14 Pleasant St - 2017-00152

I have finished my initial zoning review and at this time I cannot sign off on your change of use permit.

Proposed Home  
Occupation  
Hair Salon

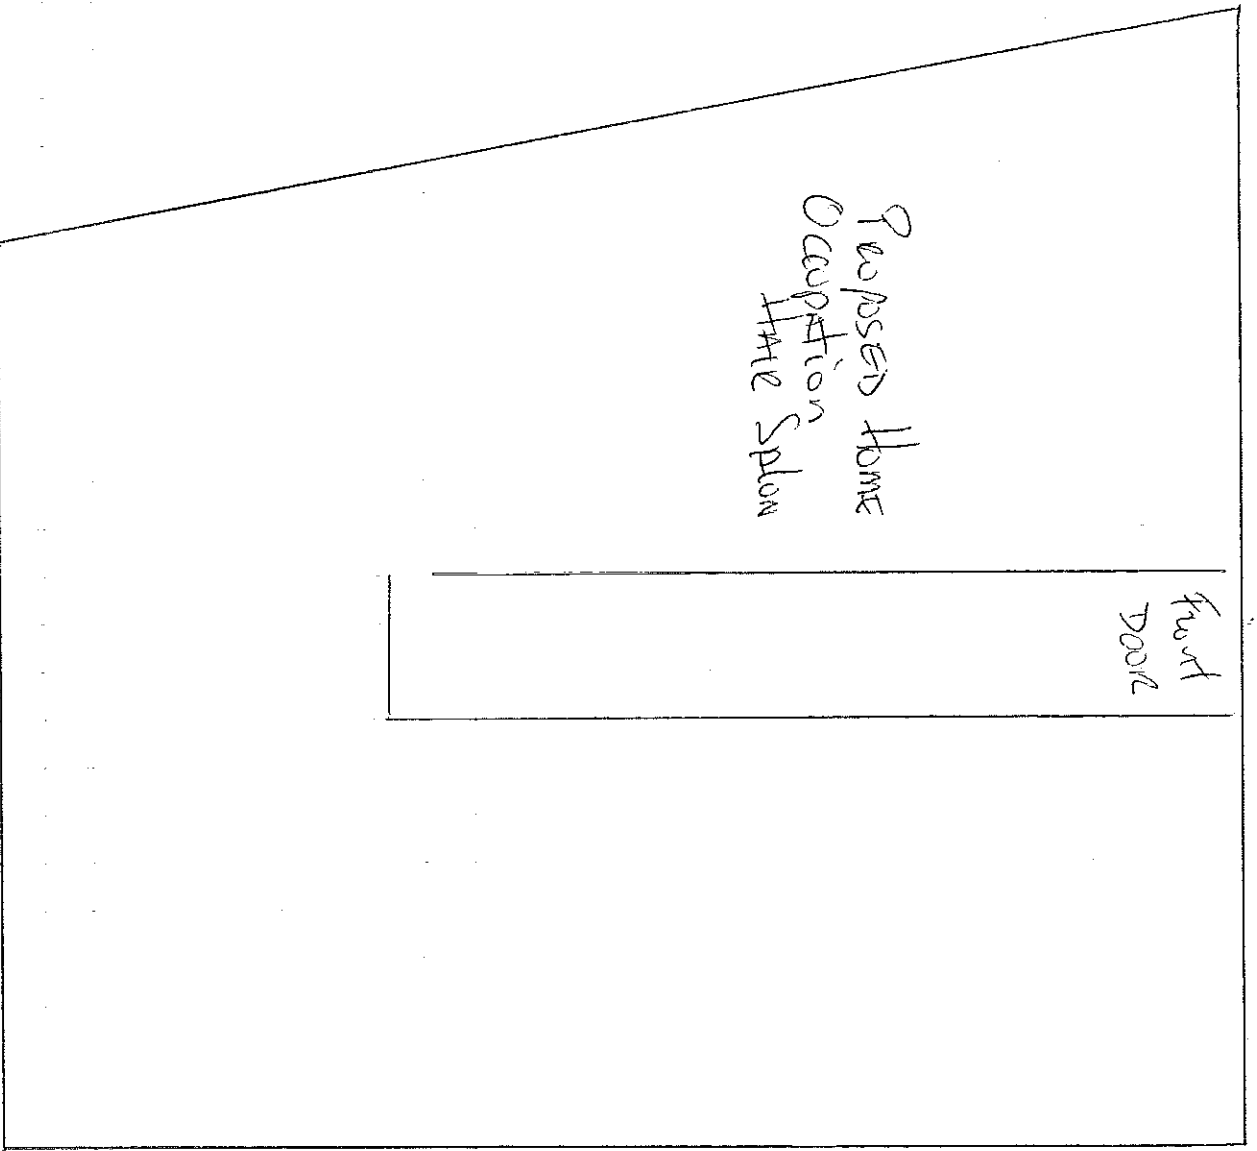
1. The property is located in the B-3 zone. This zone allows for a hair salon (personal service). You can apply for a change of use to convert half of the first floor to a hair salon and leave the other half vacant. As a change of use in the B-3 zone, you do not need to show any parking for the hair salon.
2. You need to change the use of the entire first floor to be part of the dwelling unit that exists in the rest of the building and then part of the first floor could be a home occupation if you meet the criteria of section 14-410.

1ST Floor 14 PLEASANT ST

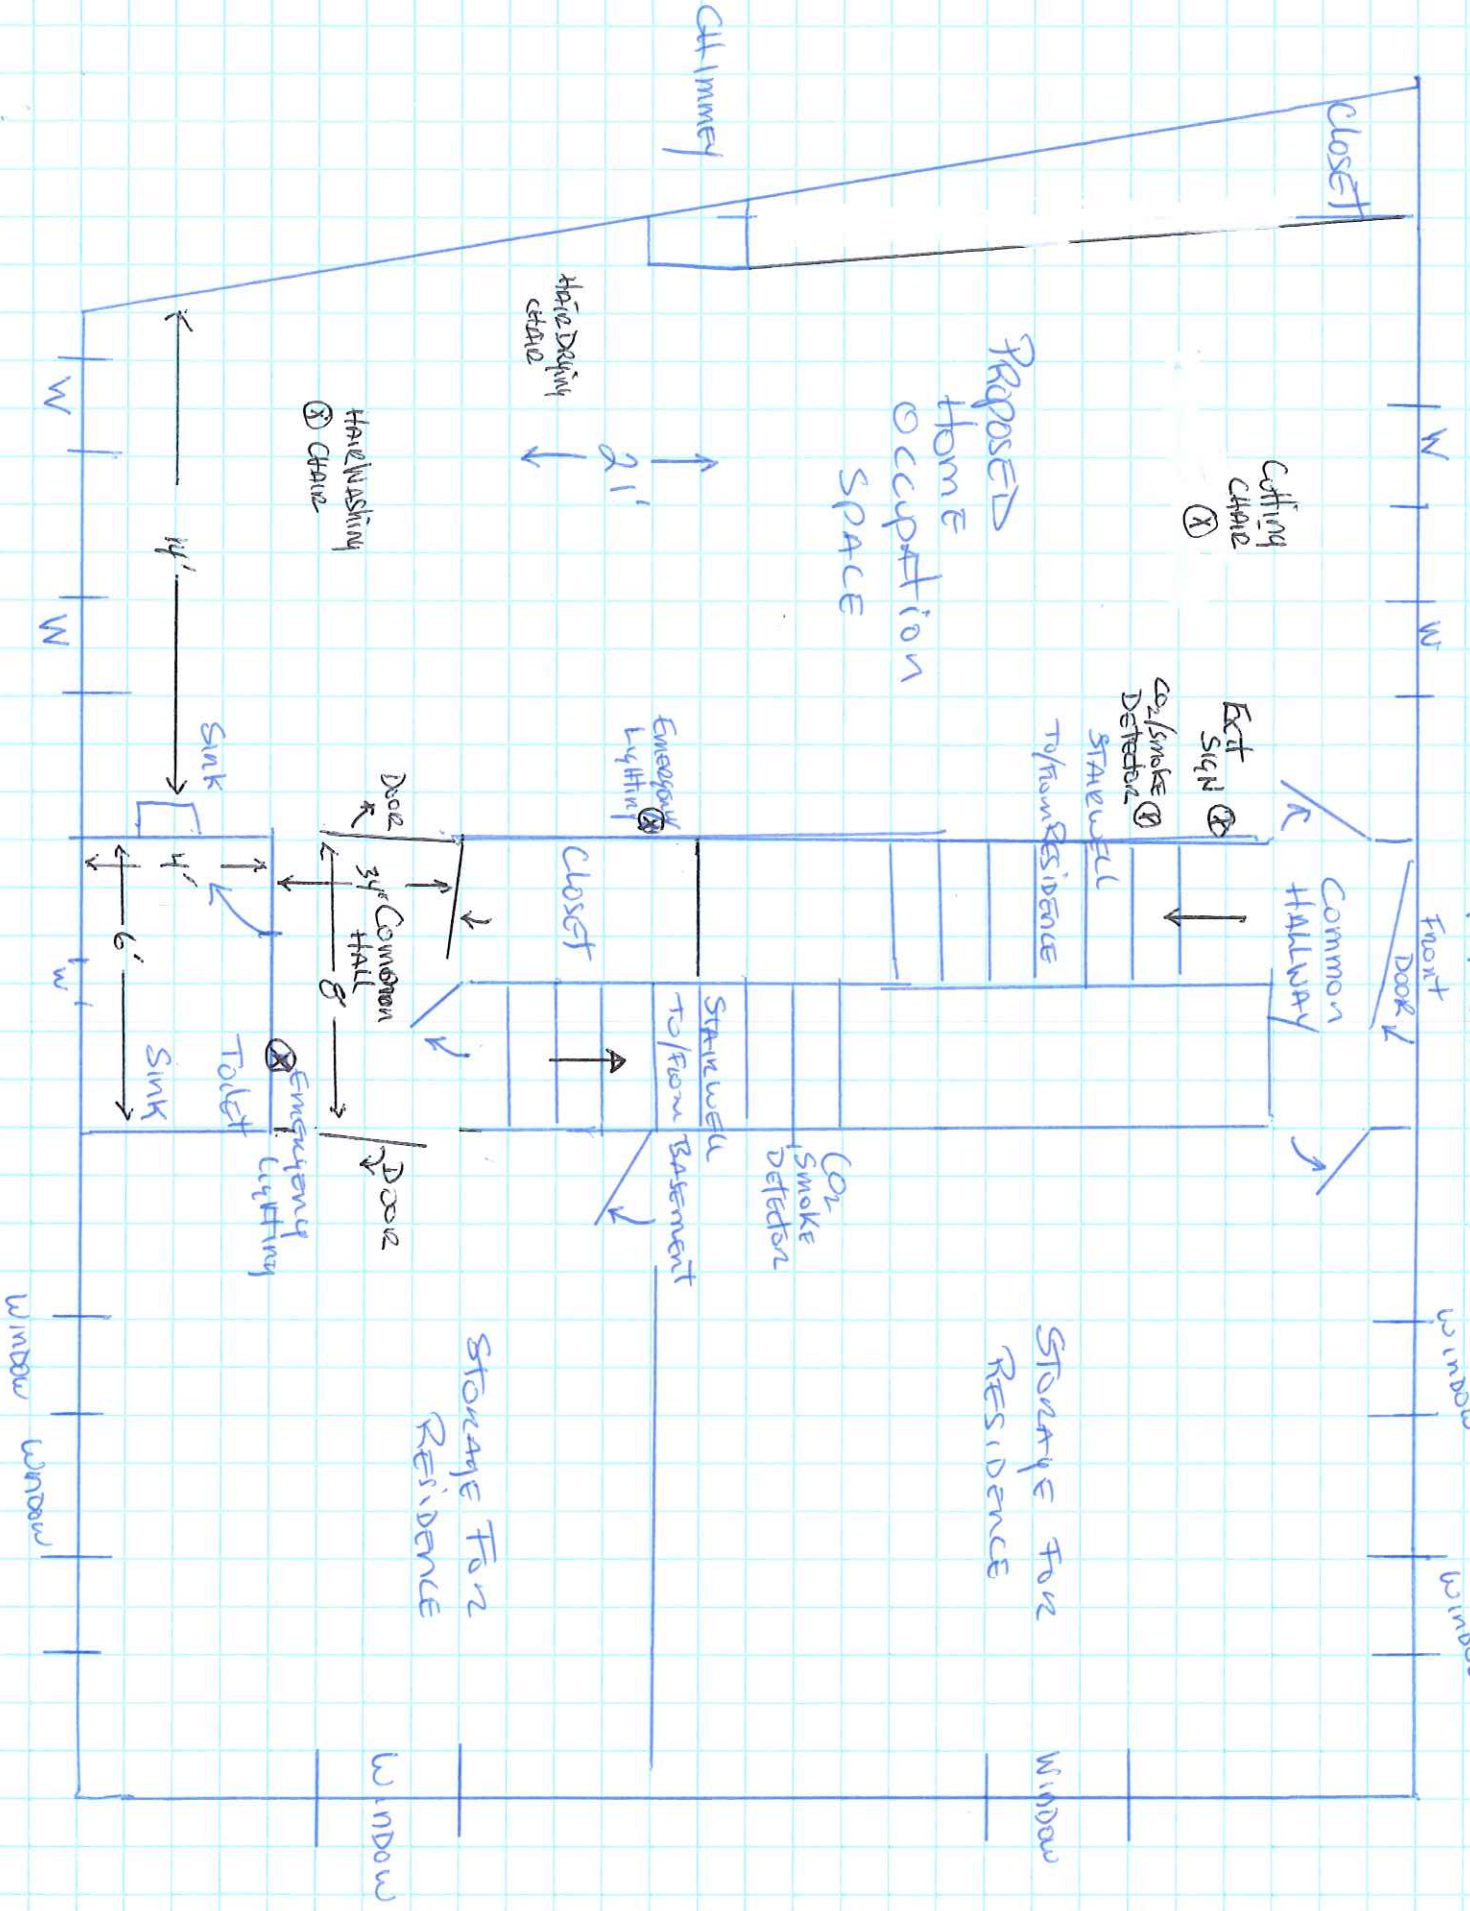
The last permit on file for the first floor of the building was permit 98-1189 which changed the use of the entire first floor to retail. The certificate of occupancy stating this use was issued on November 2, 1998. You cannot have a home occupation in a commercial space. A home occupation by definition has to be located within a dwelling unit.
